OXFORDSHIRE COUNTY COUNCIL'S RESPONSE TO CONSULTATION ON THE FOLLOWING DEVELOPMENT PROPOSAL

Application no: 14/01835/REM-4

Proposal: Reserved Matters to 05/01337/OUT - Details of the proposed village square including 44 public parking spaces and landscaped public open space | Proposed Surgery - Community Hall - Nursery Residential Longford Park Phase 2

Location: Longford Park Road Bodicote

Drwg. no 1419 | 102 | Rev E

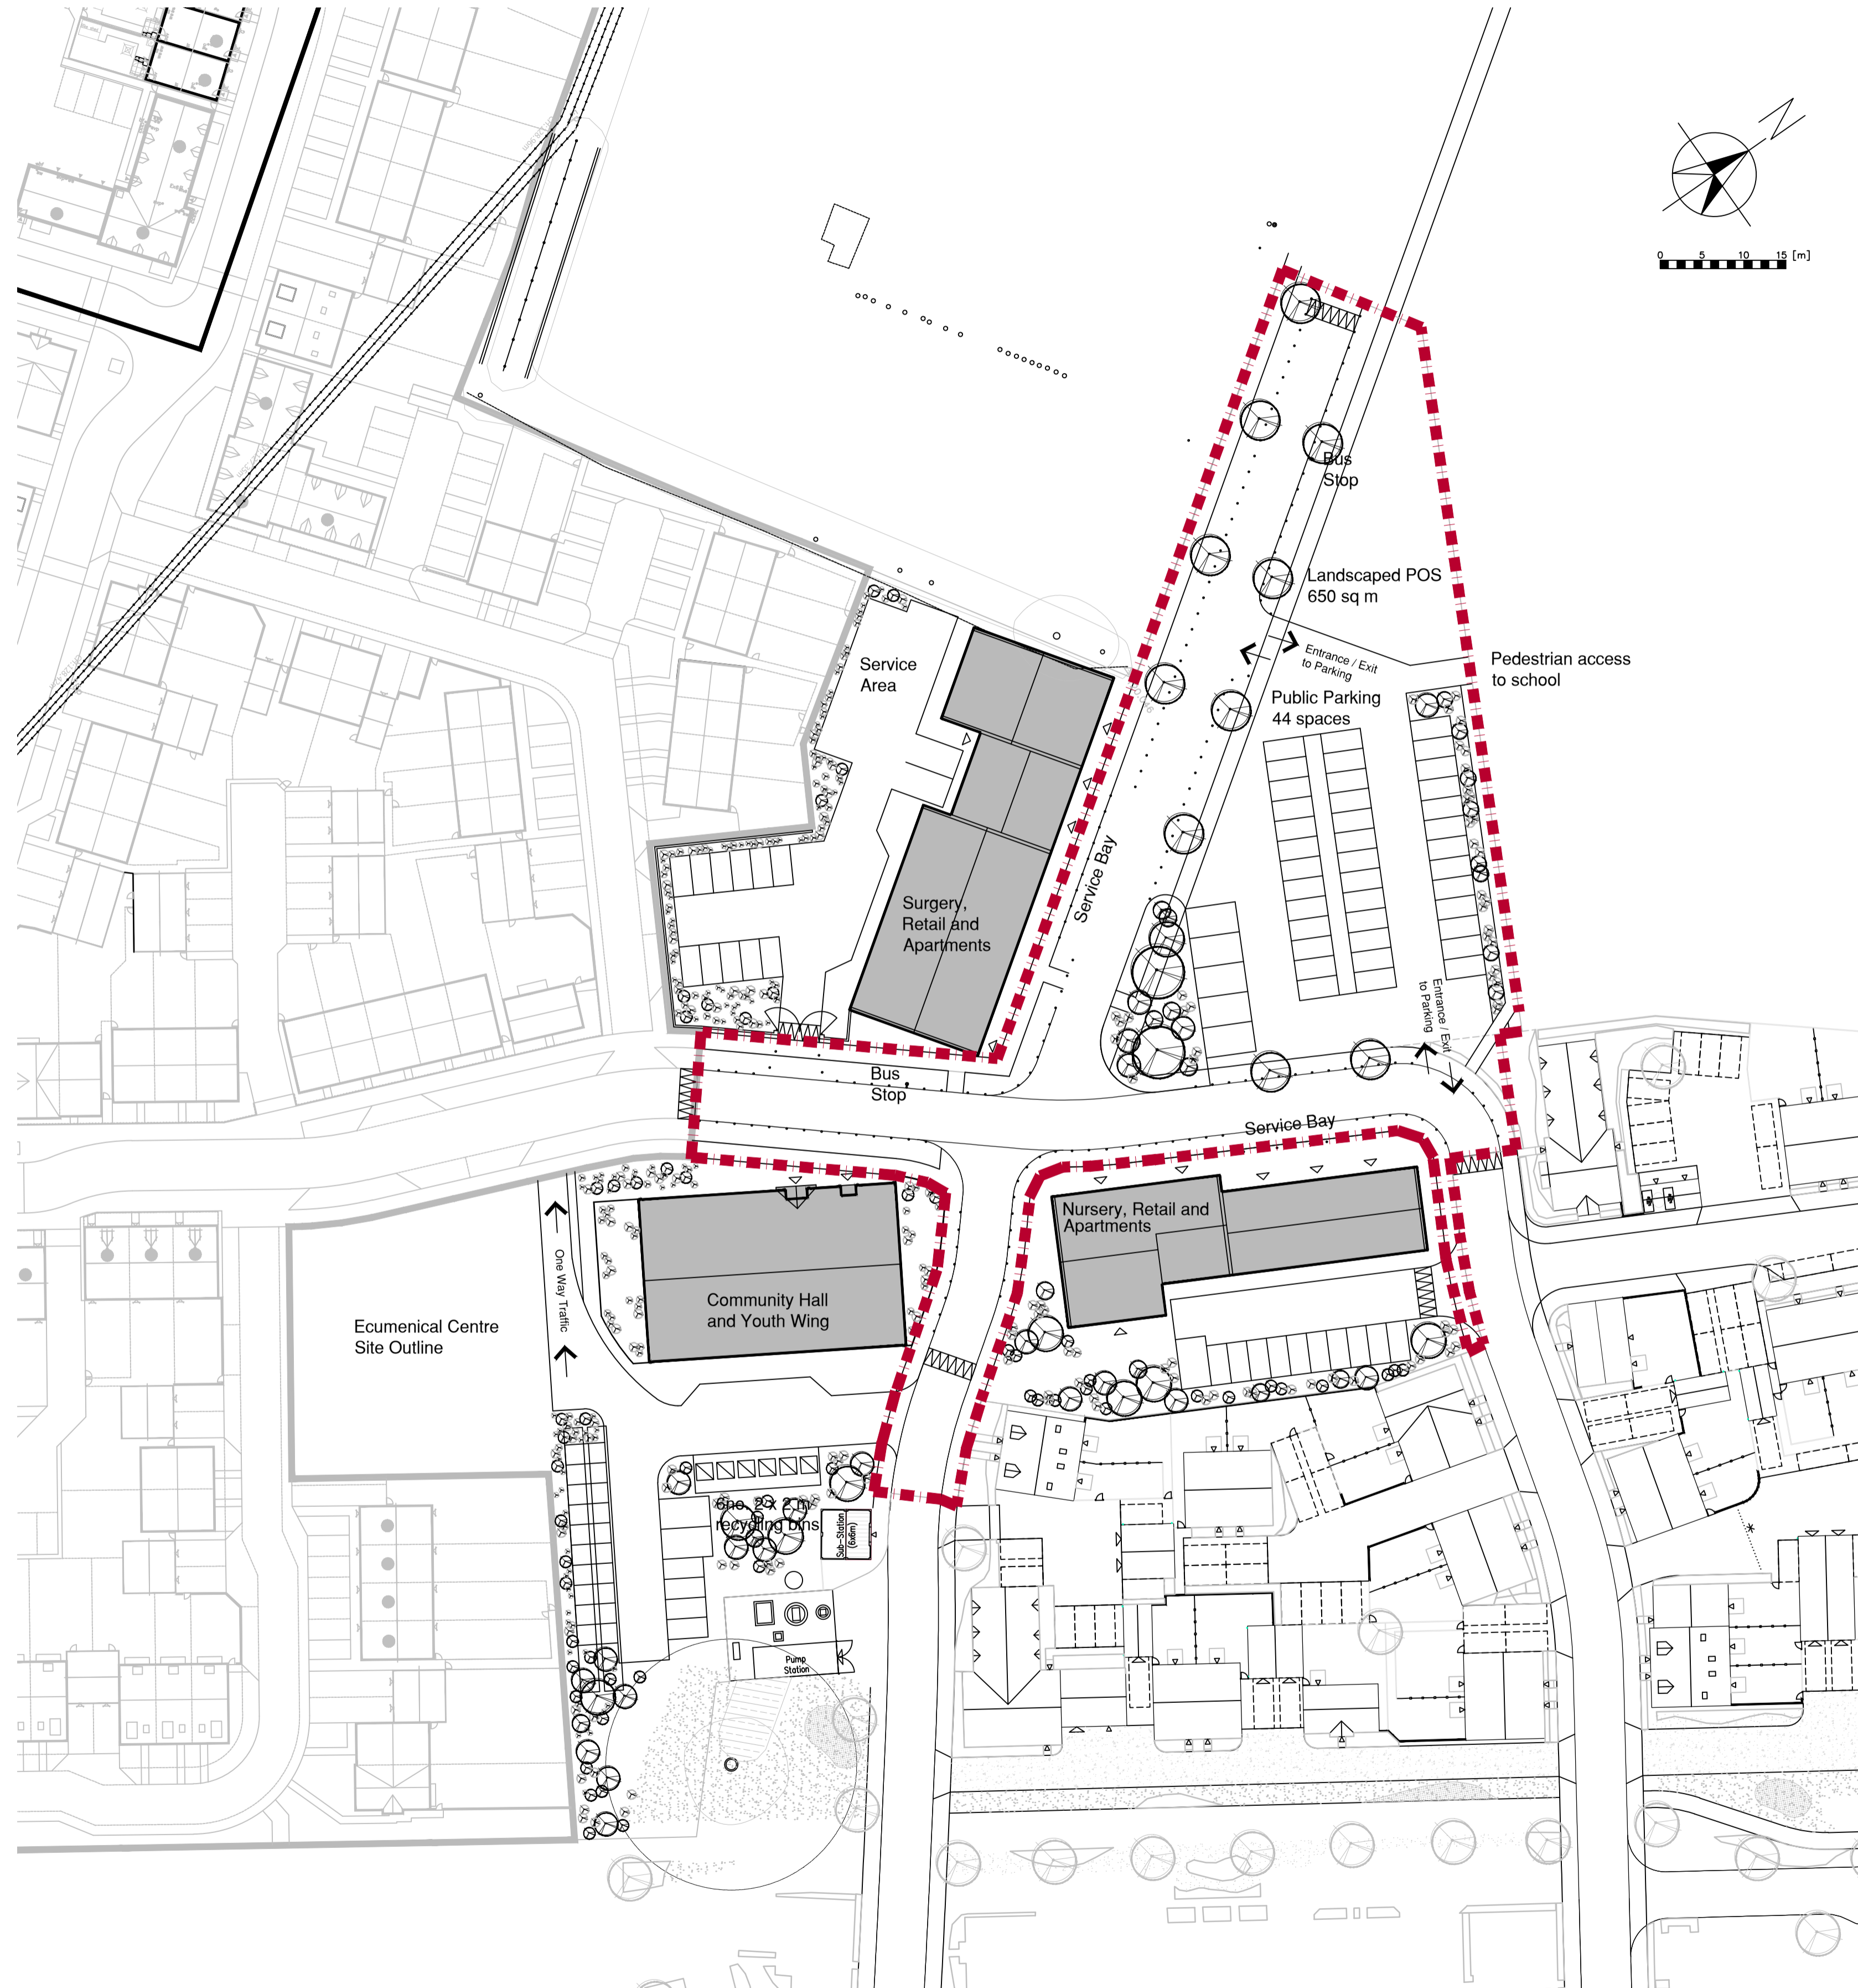
Comments on layout plan 1419-102-Rev N

- 10 sheffield stands (with appropriate spacing) were requested in our previous response to be provided. The space indicated for them is still not adequate, being roughly the space of one car parking space, considering the stands should be 1 metre apart and the space is not wide enough for two rows of stands, including the cycles parked at them. To reiterate my comments from the previous response: There needs to be enough space around each stand to conveniently park cycles without damage, or people will be discouraged from using the cycle parking. As this is short term cycle parking, I would be happy for it not to be covered, if that helps the design. The important thing is to have sufficient space to accommodate different types of bicycle including those with wider

handlebars, paniers, baskets and child carriers. The low levels of parking at the local centre mean it is extremely important to encourage people to walk or cycle there rather than to drive – that includes people bringing children to school – parents' bikes are unlikely to be allowed on school premises. Given my concerns that insufficient space is being allocated to cycle parking, I would like to see a plan showing how the individual stands are laid out.

- The car park now has one entry/exit point. Tracking was requested to show that cars entering and leaving the car park can pass one another at this access, to avoid cars having to wait on the spine road, causing congestion on the bus route. As recycling bins have been introduced, this must also allow for the larger glass collection vehicles that will need to enter the car park. The application documents do not appear to include a drawing showing vehicle tracking.
